Rezoning Transportation Analysis

Petition Number: 2025-100

General Location Identifier: 14922399

Date	Description
9-24-25	First Review (NK)
10-23-25	Second Review (NK)

RZ-1.0

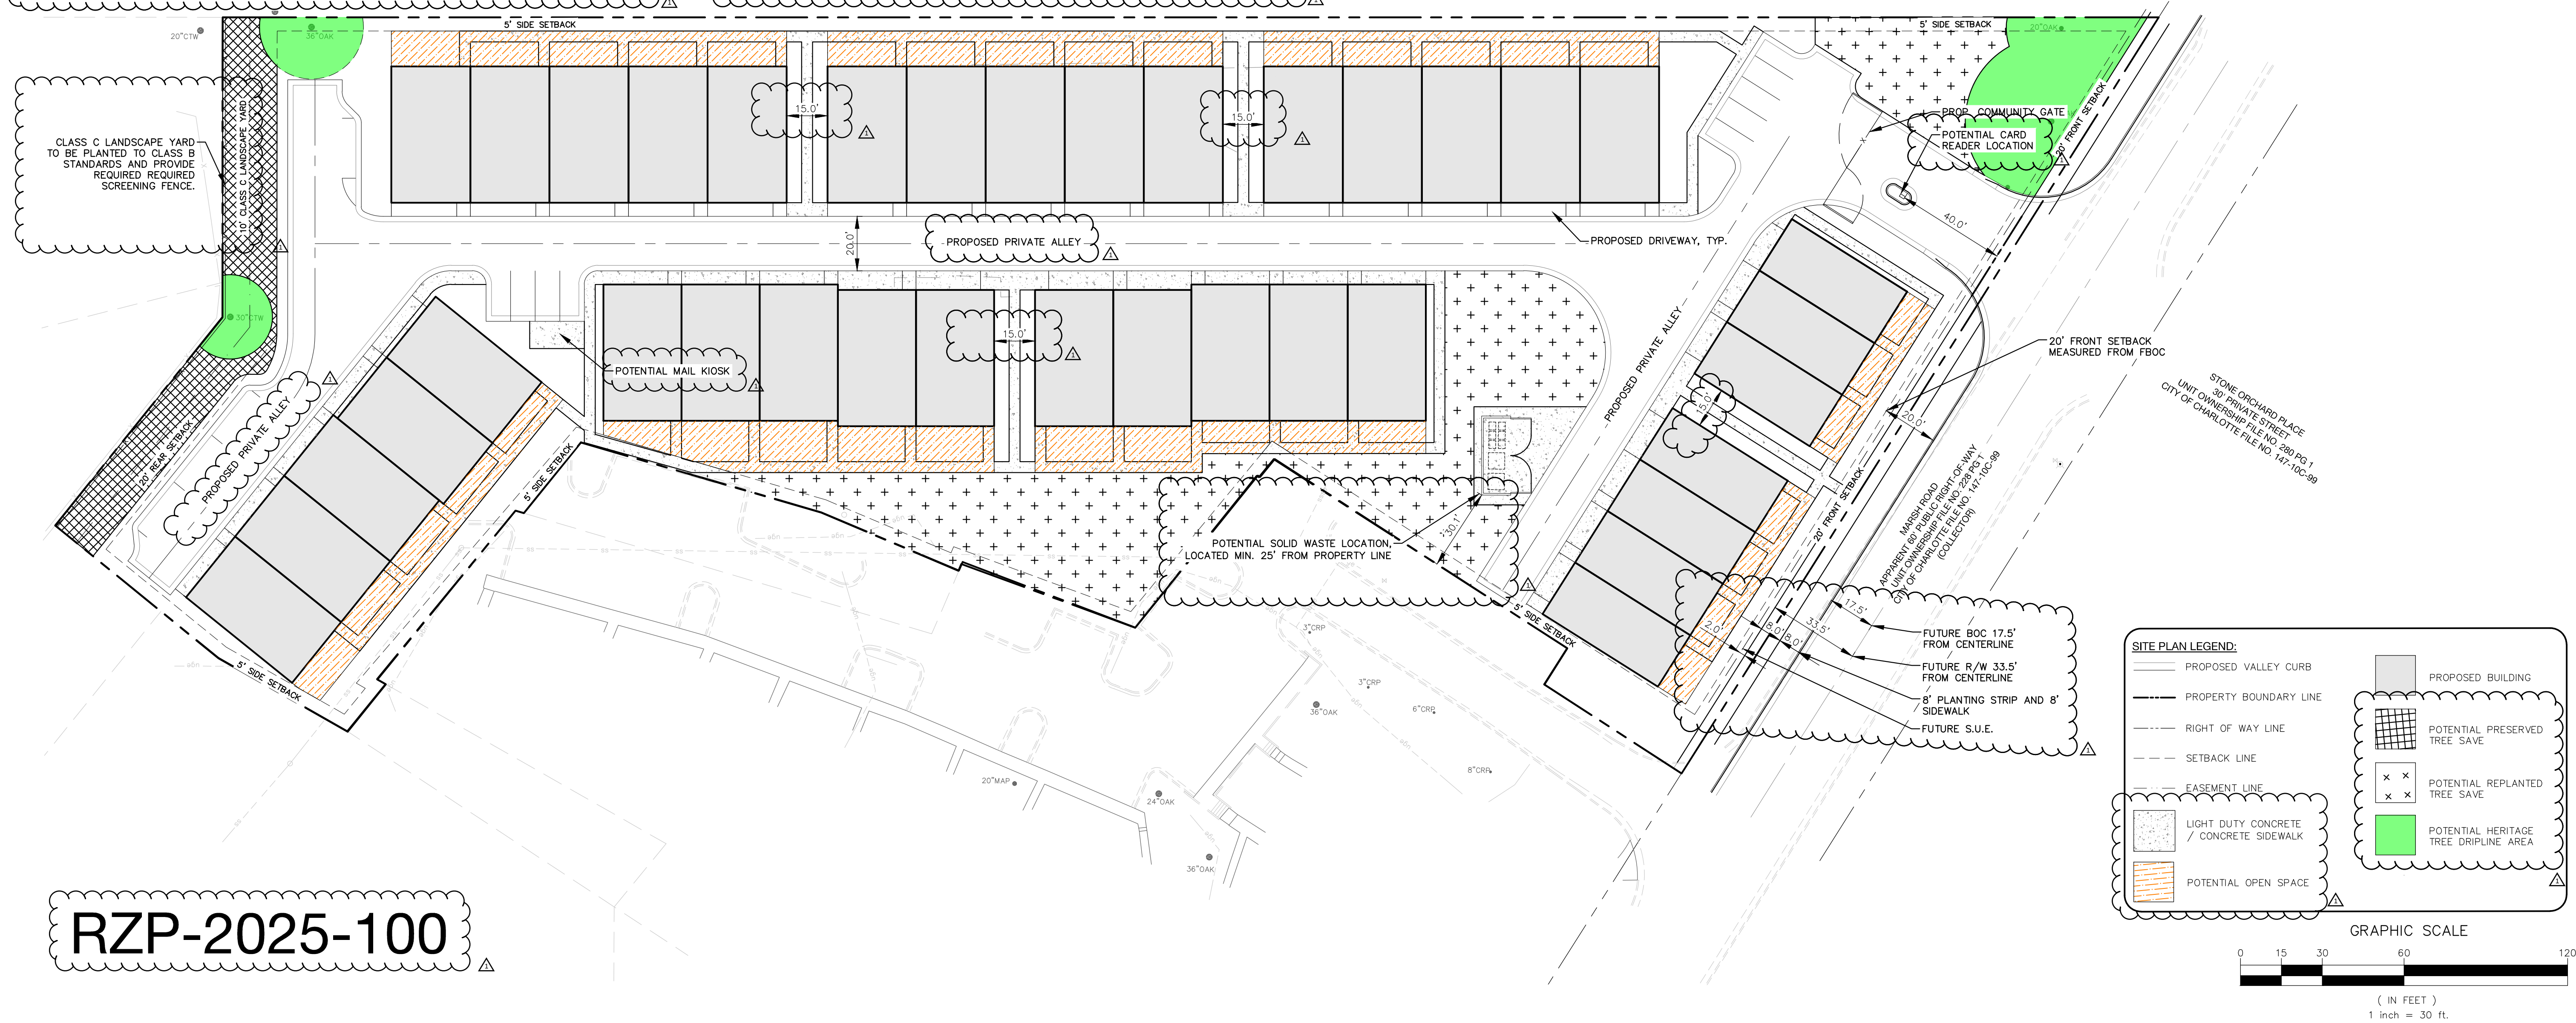
13. **New Comment 10.22.25:** Clarify highlighted part shown in note below.

If a security gate is provided, adequate space shall allow for maneuvering outside the right-of-way for vehicle turnarounds and a minimum 40' shall be provided between any card reader and the back of sidewalk.
